PRE-HEARING STAFF ANALYSIS

Rezoning Petition No. 2008 - 086

Property Owner:	Citiline Resortline Properties of the Carolinas, LLC
Petitioner:	Citiline Resortline Properties of the Carolinas, LLC
Location:	Approximately 2.43 acres located on both sides of Victoria Avenue north of West 4 th Street Extension and also on the east side of South Irwin Avenue north of West 4 th Street Extension
Center, Corridor, or Wedge:	Center
Request:	UR-1, urban residential and UR-2, urban residential to MUDD-O, mixed use development district optional

Sheet:
RZ-2

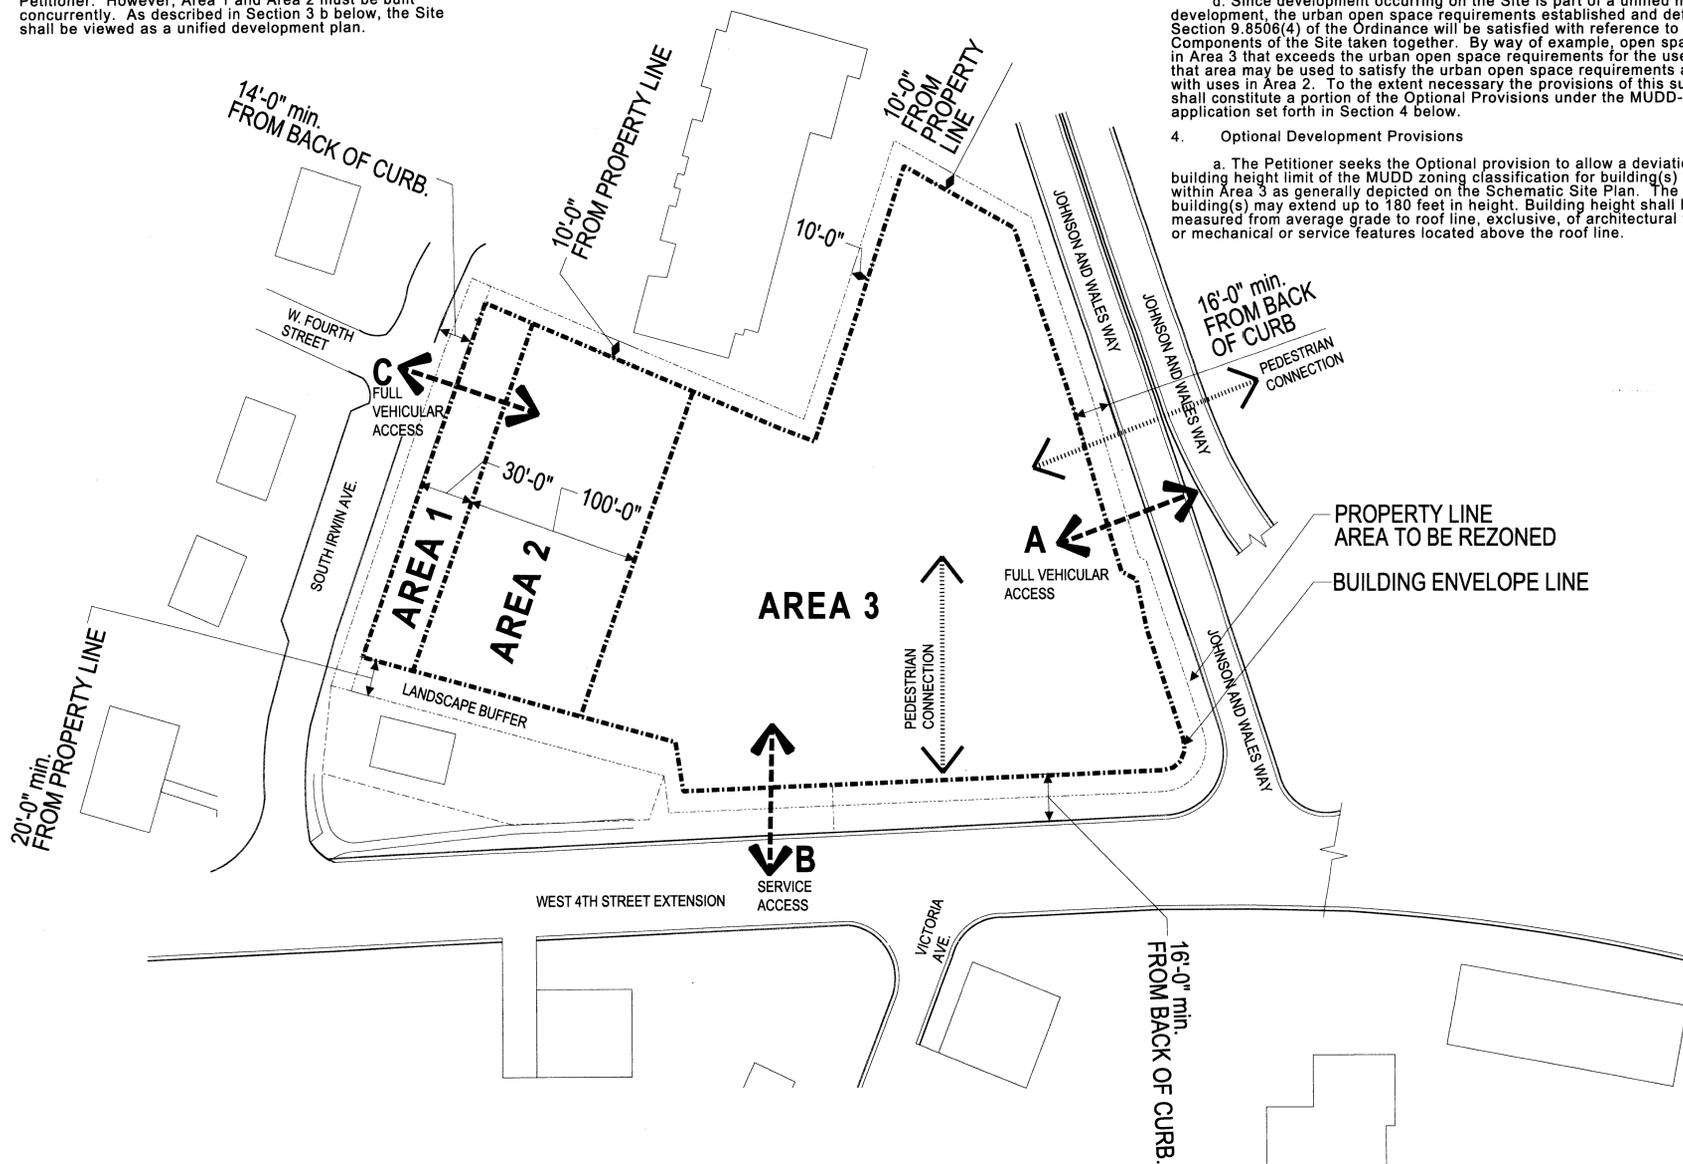
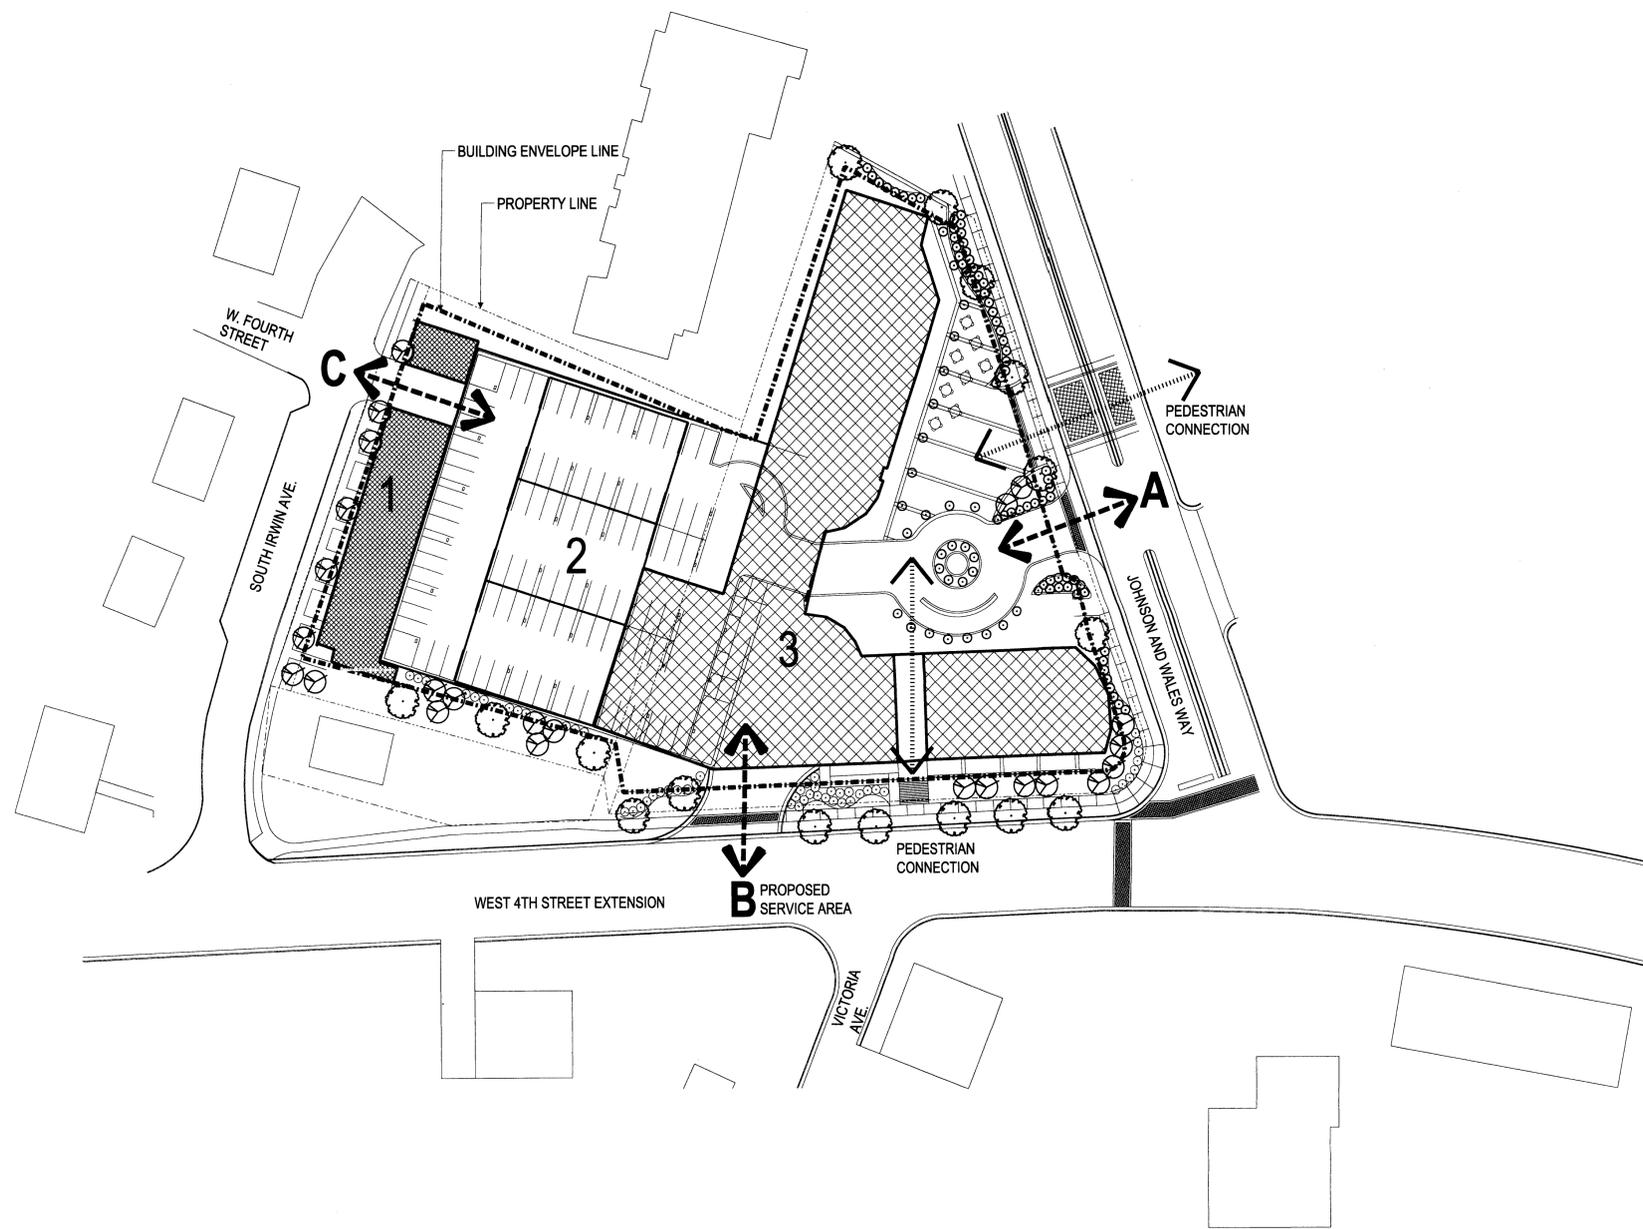
- Note four under “Optional Development Provisions” and five (b) and (c) under “Design and Performance Standards” conflict regarding how height will be measured. The notes indicate height will be measured per the ordinance and then excludes devices used to screen structures and equipment. These devices would allow additional height as defined in the ordinance. The petitioner should exclude references to these devices.
- The petitioner should correct the lighting note to indicate all lighting fixtures will be shielded with full cut-off.
- The petitioner should label the open space on the site plan and include improvements.
- The petitioner should address CDOT comments.
